ferring parish council
1 elm park

Your Ref: OWPC16401
Our Ref: FG/162/17/PL 10-10-2017
Please ask for:
Mrs A Gardner

Demolition of existing detached garage & erection of 1 No. dwelling.
1 Upper West Drive Ferring

PROPOSED GROUND FLOOR PLAN 1:100

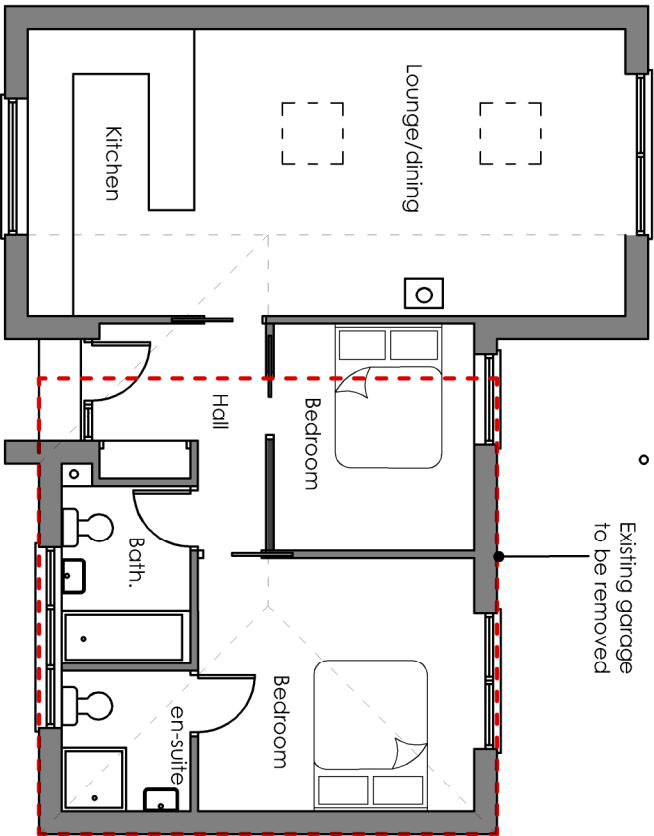
This proposal is undeniably an overdevelopment of a plot of land that is not suitable to accommodate an additional dwelling. Within the proposal there is very little provision amenities and the applicant has already suggested that there is inadequate space for the rear garden.

The boundaries of the proposed dwelling are exceptionally narrow on both the north and the south side causing a reduction in the privacy and intruding on the neighbouring property. Furthermore, the proposed dwelling will alter the ambiance and character of the area.
